**CITY OF ALBUQUERQUE
PLANNING DEPARTMENT
February 3, 2016
DRB Comments**

PROJECT # 1010731

RE: Lots 11 & 12, Block 13, University Heights

PLAT OF
LOT 12-A, BLOCK 13
UNIVERSITY HEIGHTS

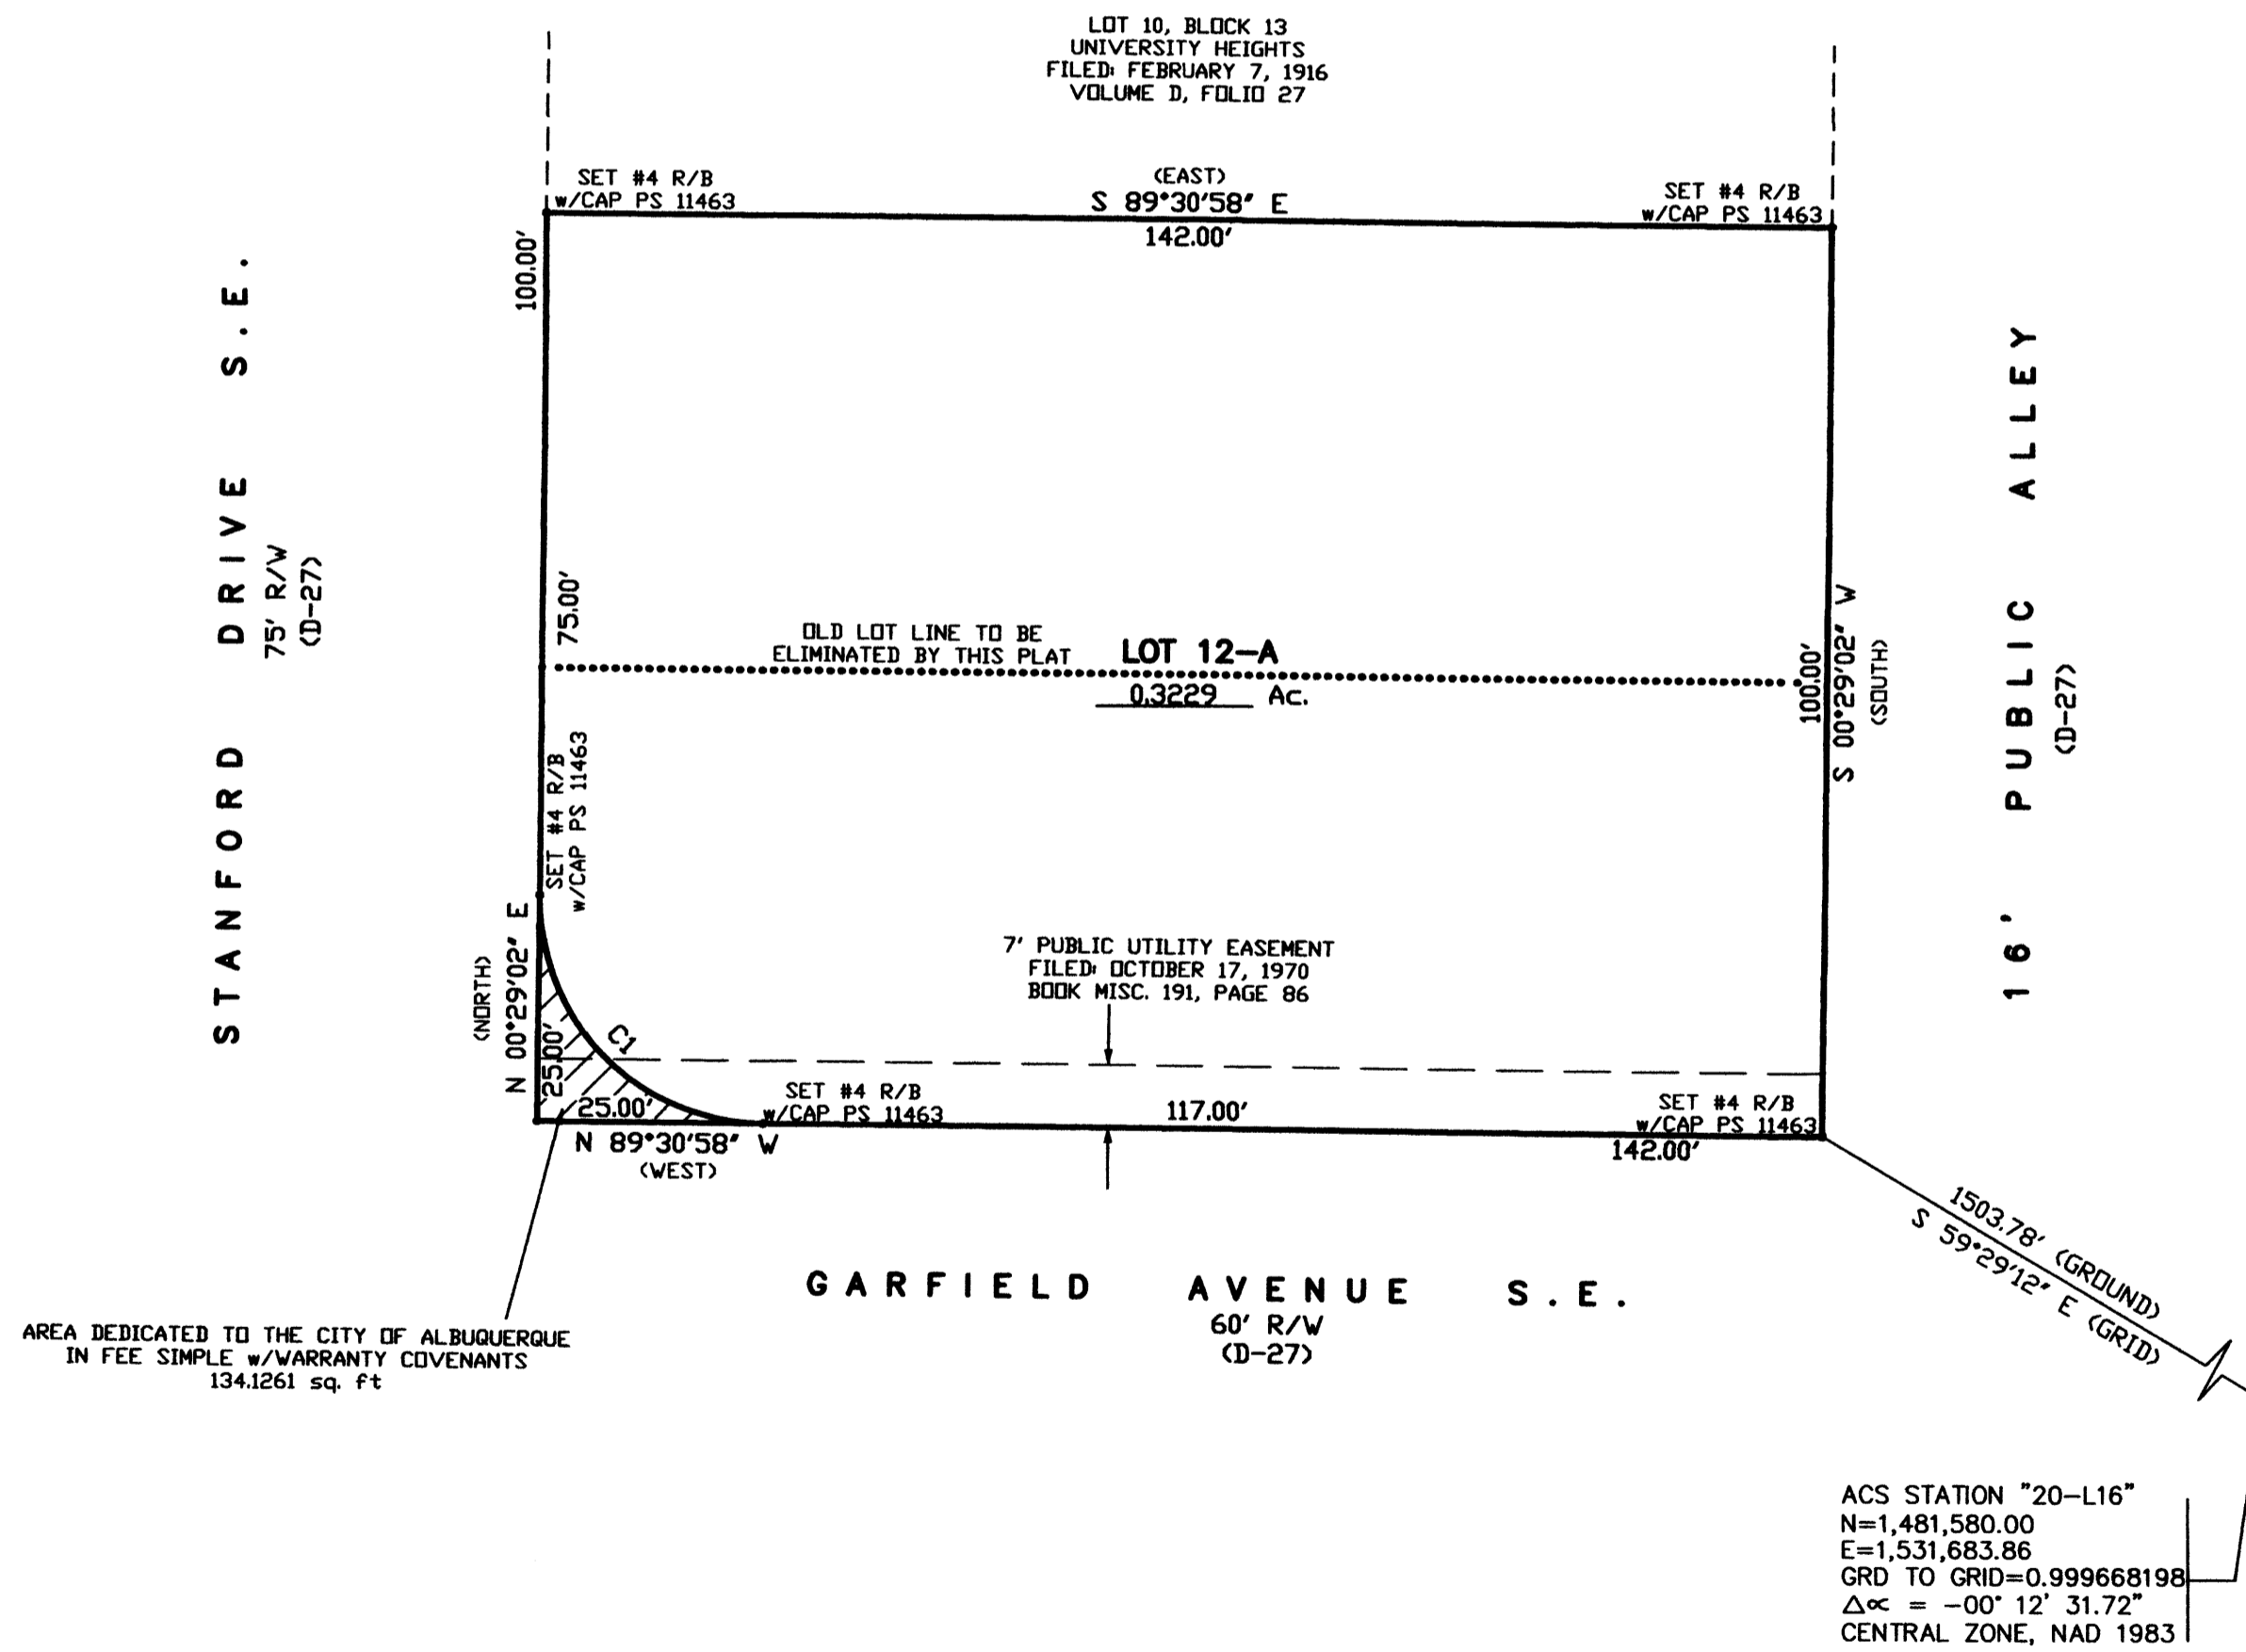
Existing Lots 11 & 12 have distinct/ different zoning designations; the 'Old Lot Line' needs to be memorialized on the plat as a Zone Boundary.

Planning: AMAFCA, identify "Zone Boundary" OK dxp
